Date: 8 July 2026
PINS Ref: EN0710010
Our Ref: 17996

EN0710010 – EAST COAST HYDROGEN TEESSIDE PIPELINE (NORTHERN GAS NETWORKS)

We write on behalf of Net Zero North Sea Storage ('NZNSS'), in respect of Northern Gas Network's ('NGN' / the 'Applicant's') proposed development consent application for the East Coast Hydrogen Teesside Pipeline Project (the 'ECH Teesside Project'). NZNSS is an undertaker for the purposes of the development consent order granted in respect of the Net Zero Teesside Project.

Drawing Title
Figure 1.3 - The Scoping Boundary Aerial

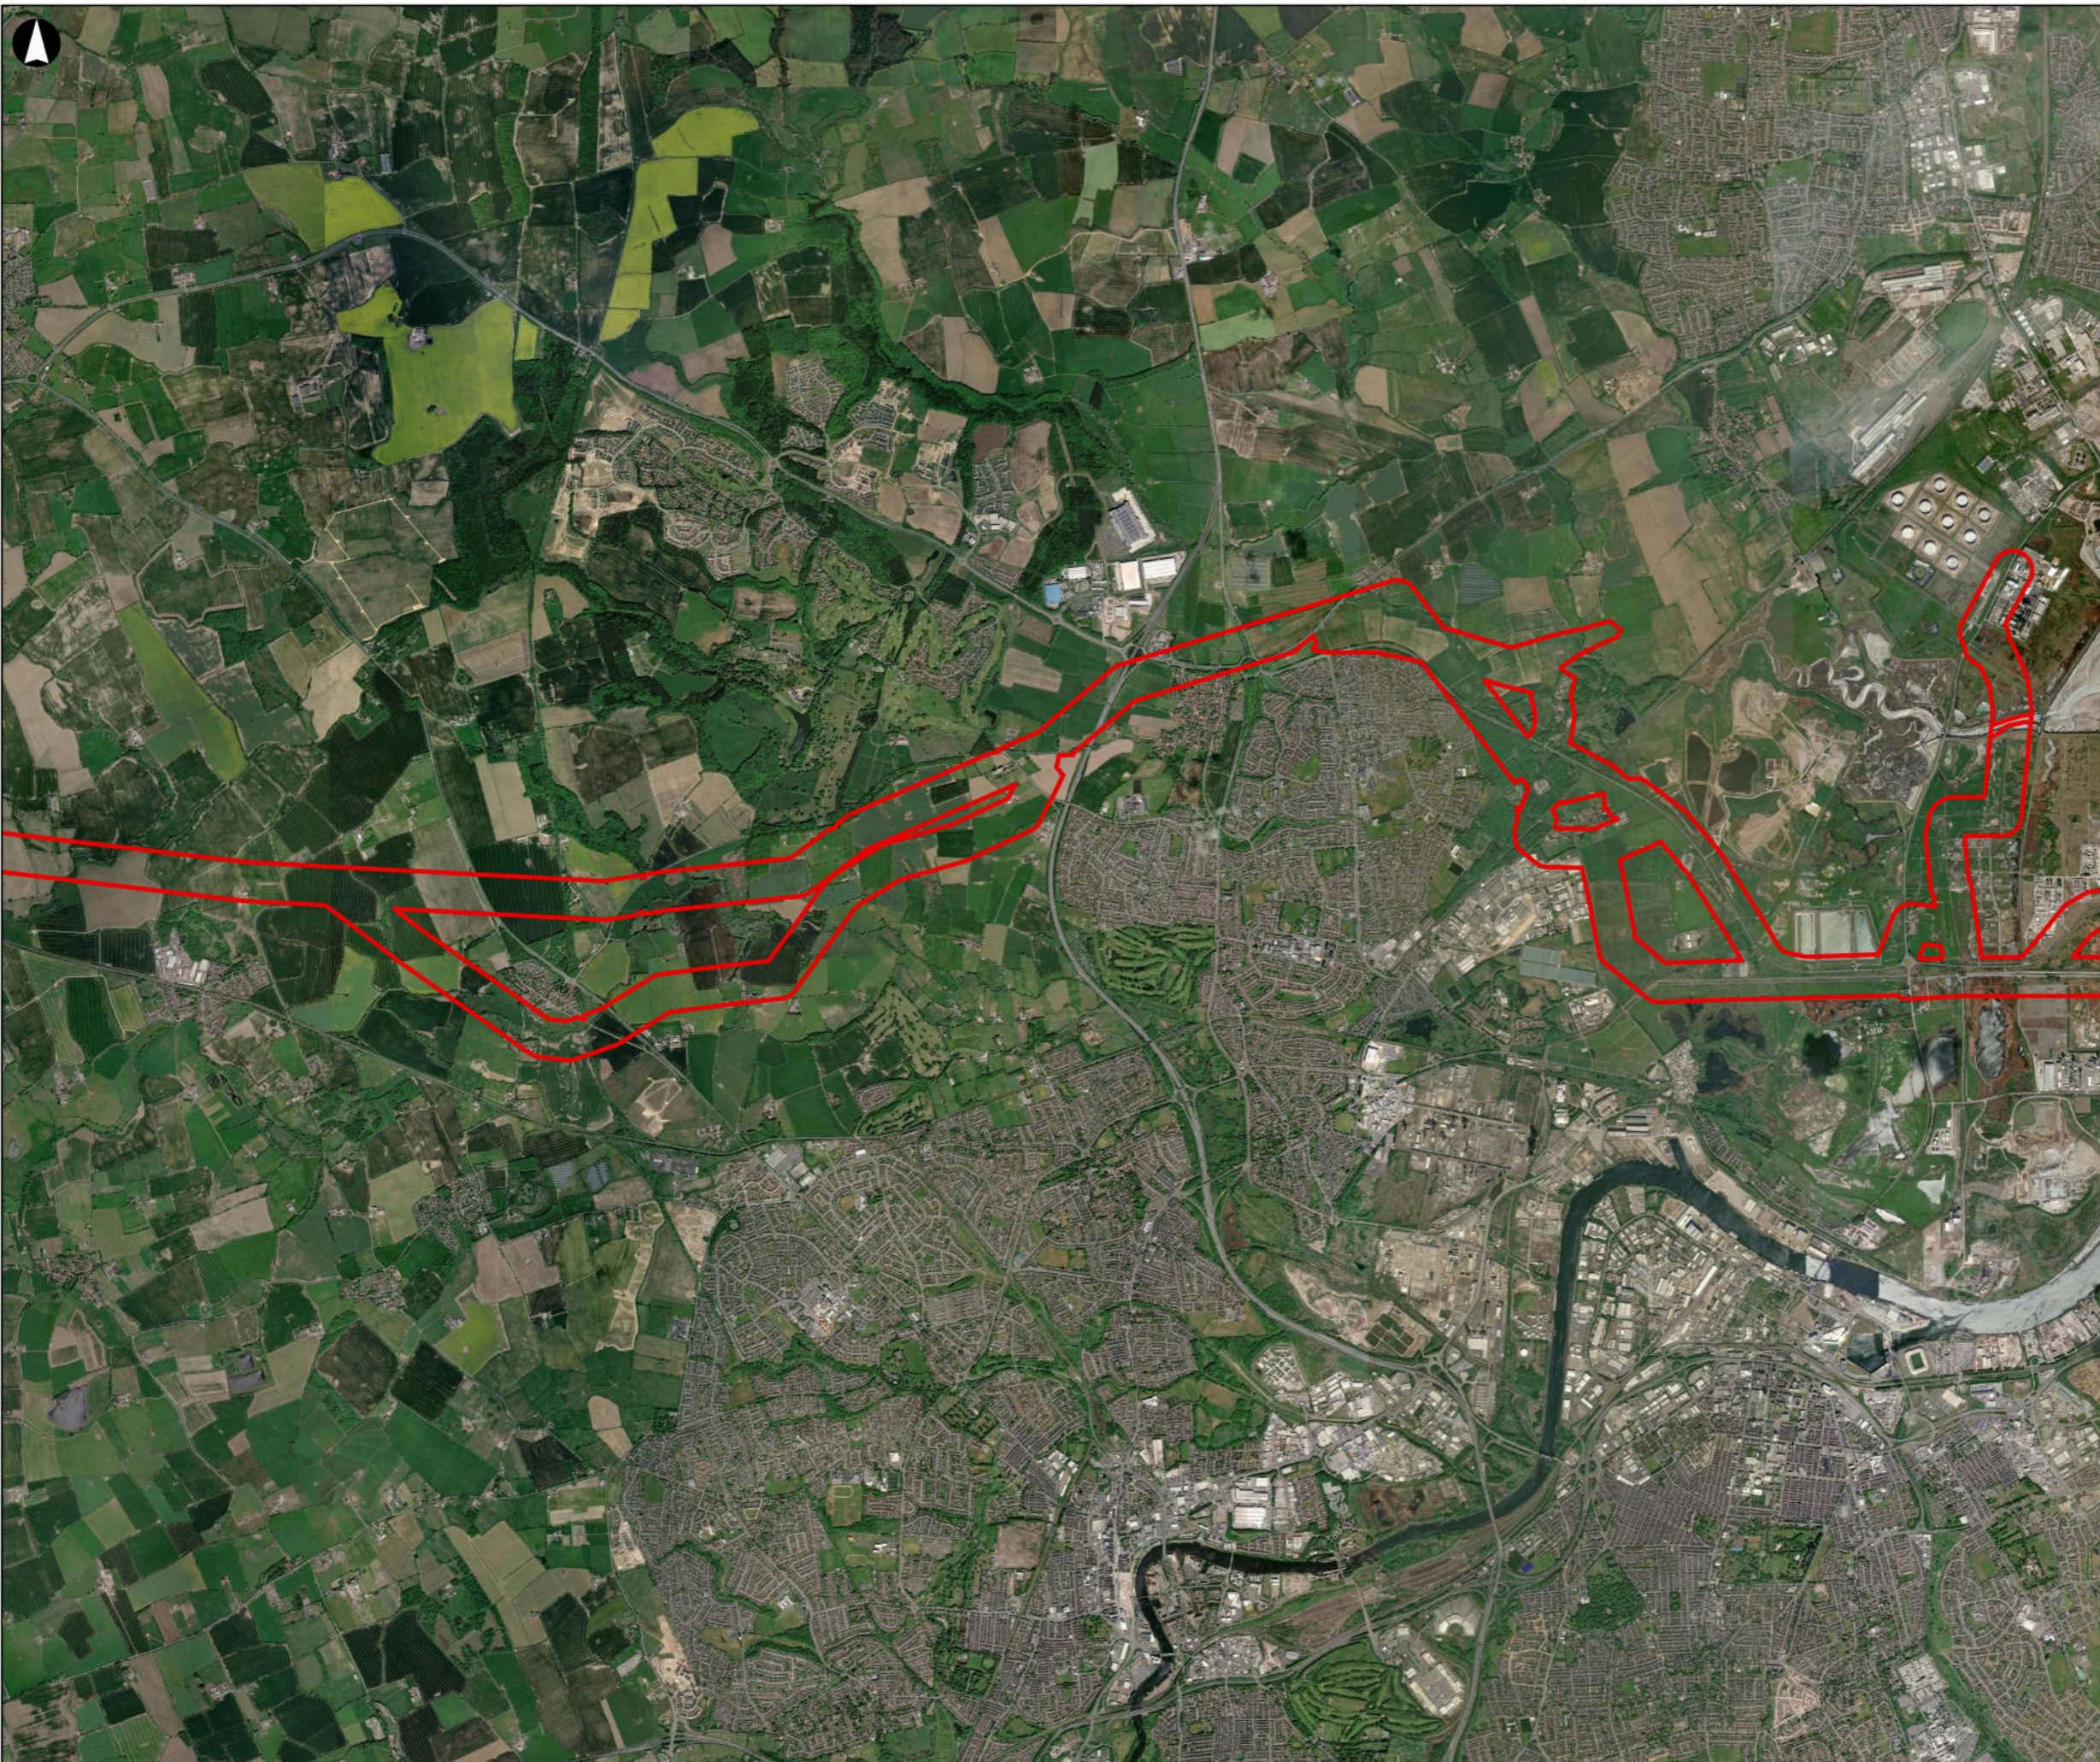
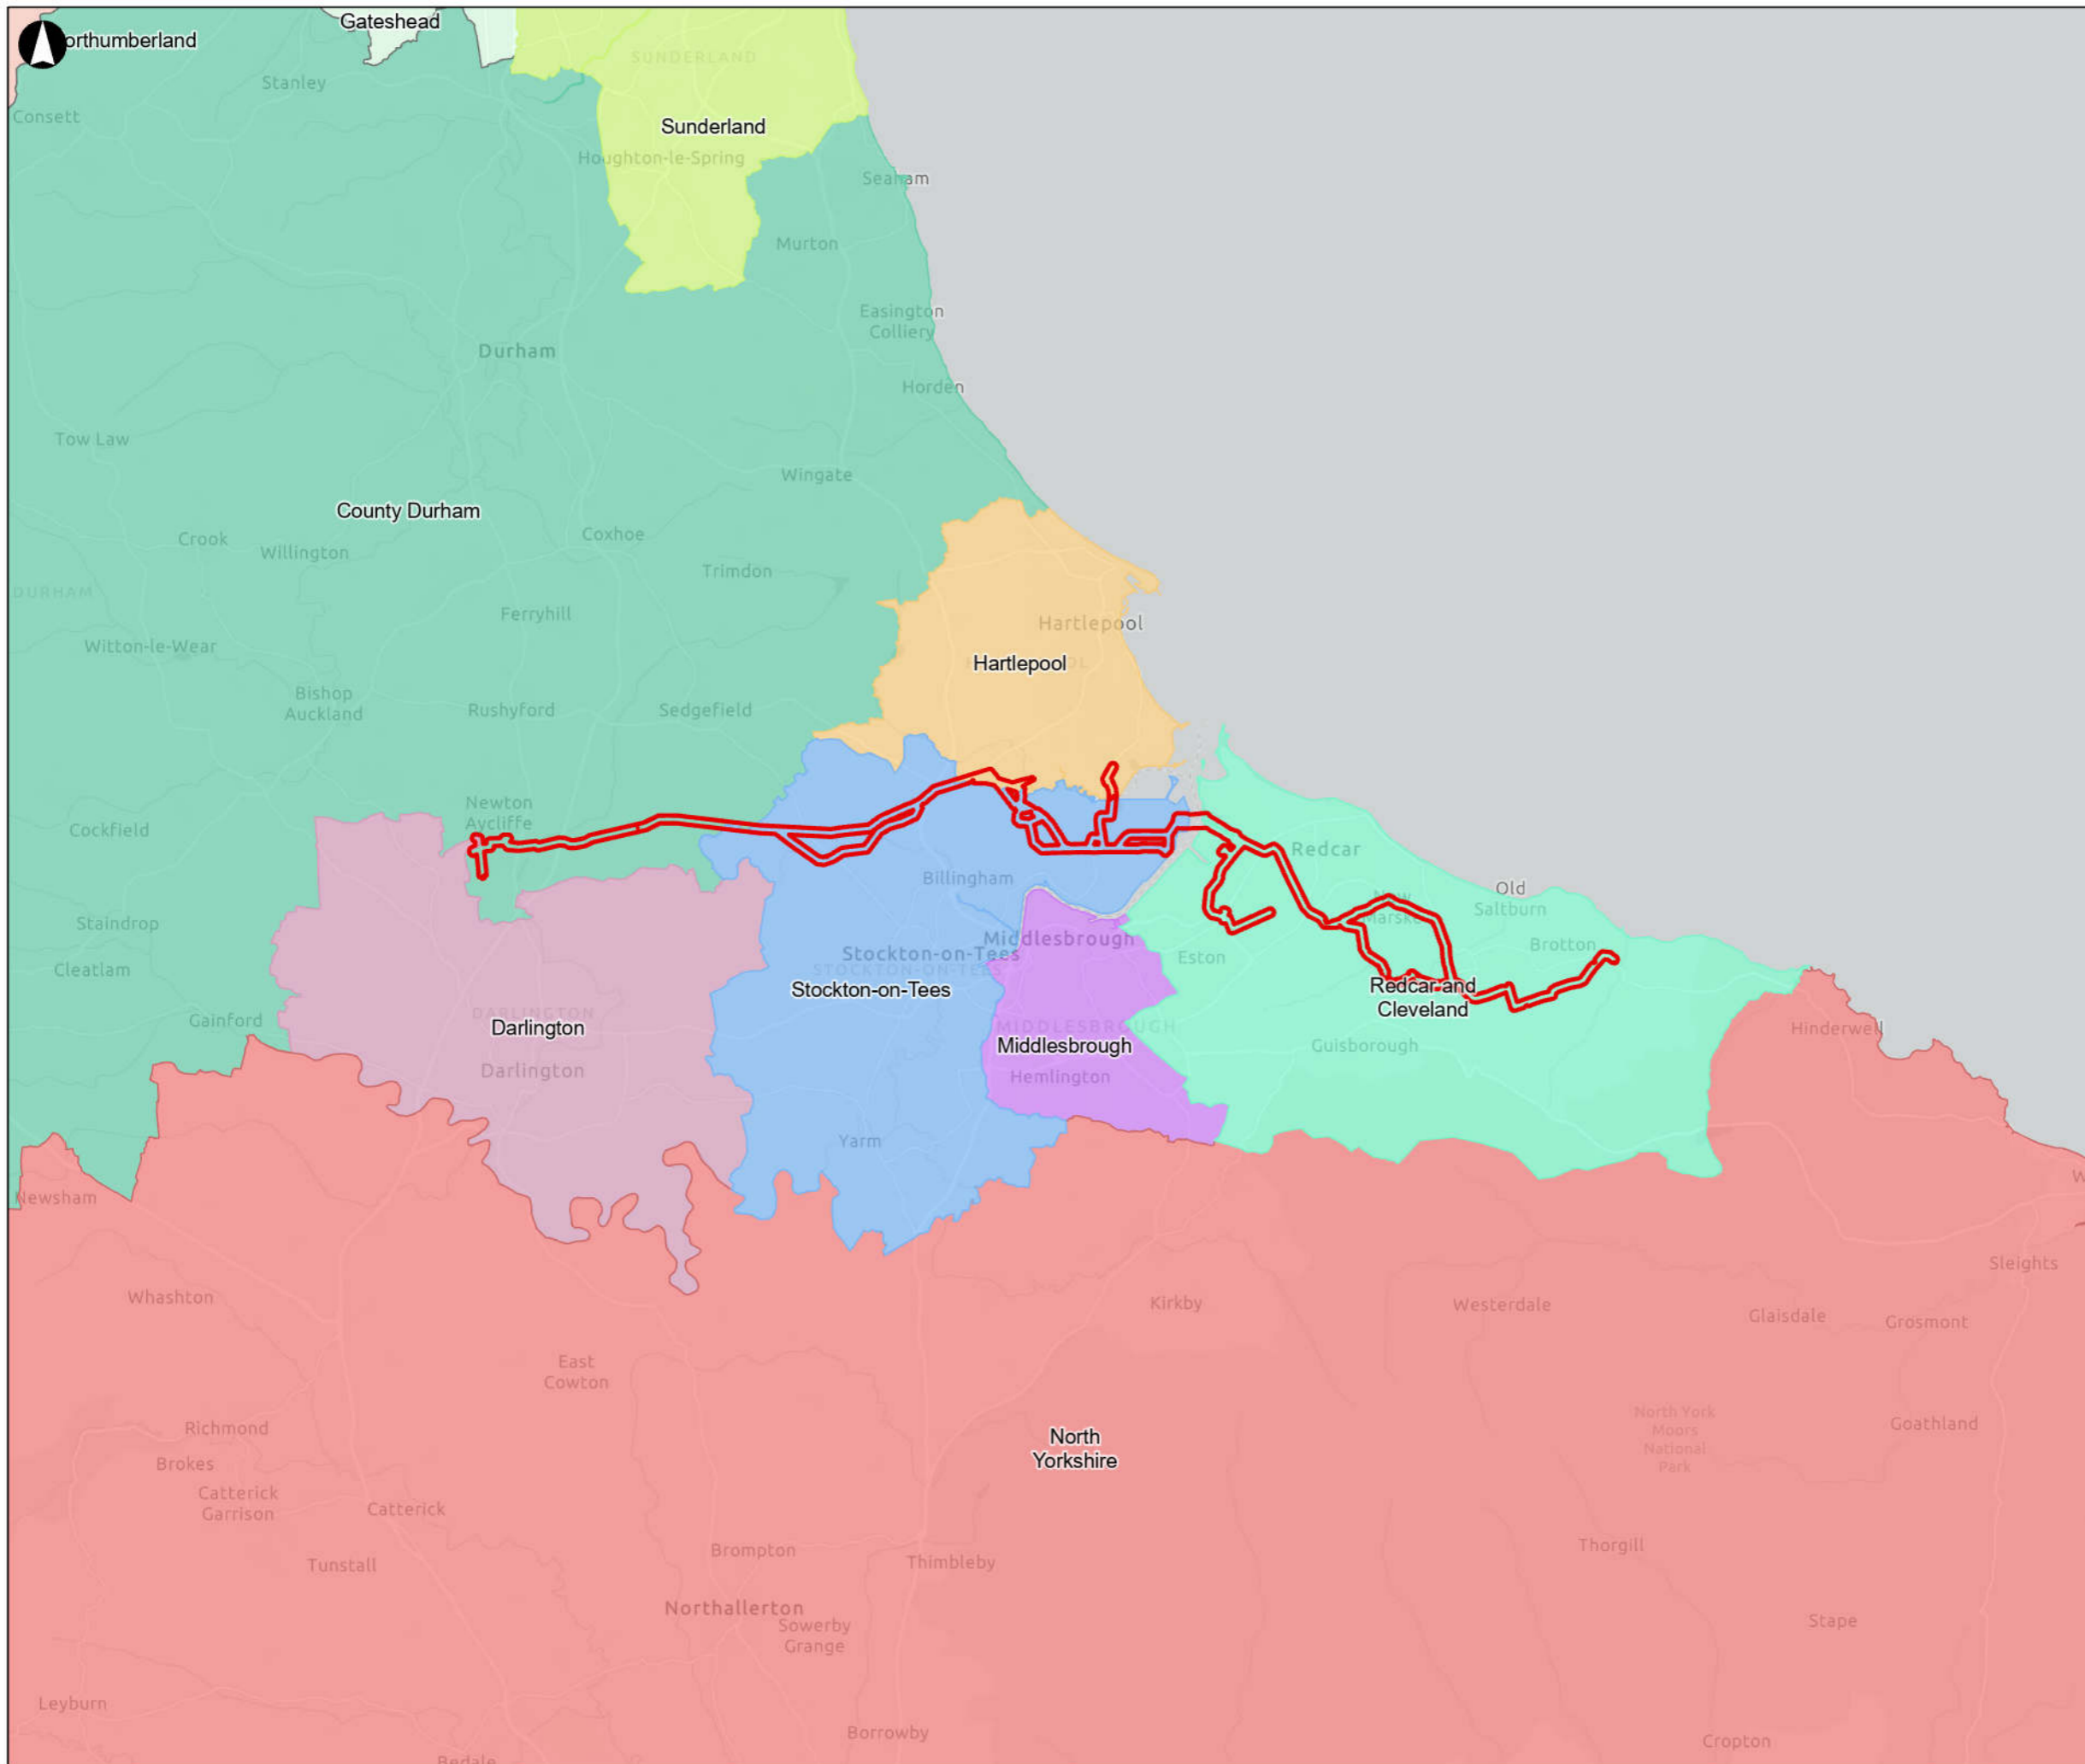
NZNSS notes that NGN has submitted an application for an Environmental Impact Assessment ('EIA') scoping opinion in respect of the ECH Teesside Project to the Secretary of State for Energy Security and Net Zero. We have reviewed the EIA Scoping Report, notably Figure 1.2 (Rev P01) and Figure 1.3 (Rev P01) which show the Scoping Boundary, and Figure 4.1 which shows the Indicative Site Layout, and wish to make you aware of the interactions and overlaps of those with the confirmed Order limits for the Net Zero Teesside Project.

It is evident from a review of the ECH Teesside Project's EIA Scoping Report and the NZT Works Plans, that there are significant interactions and overlaps between NGN's Scoping Boundary (Figures 1.2 and 1.3) and the NZT Order limits for the NEP Project. In particular, the proposed Scoping Boundary for the ECH Teesside Project, includes land that is within (or is in close proximity to) the carbon dioxide gathering network (Work No.6); and above ground installations (Work No. 6A) within the confirmed Order limits for NZT.

Having regard to the above, it is crucial that the Order limits for the NEP Project are taken into account by NGN in undertaking its EIA of the ECH Teesside Project, and that the ECH Teesside Project does not impact on the delivery of the NEP Project given its importance within the ECC. It will be of significant interest to NZNSS as to how the Applicant plans to install the infrastructure comprising the ECH Teesside Project while protecting, and facilitating ongoing future access to NEP's infrastructure. NZNSS is also concerned that the ECH Teesside Project may have a safety impact on NEP. Given these
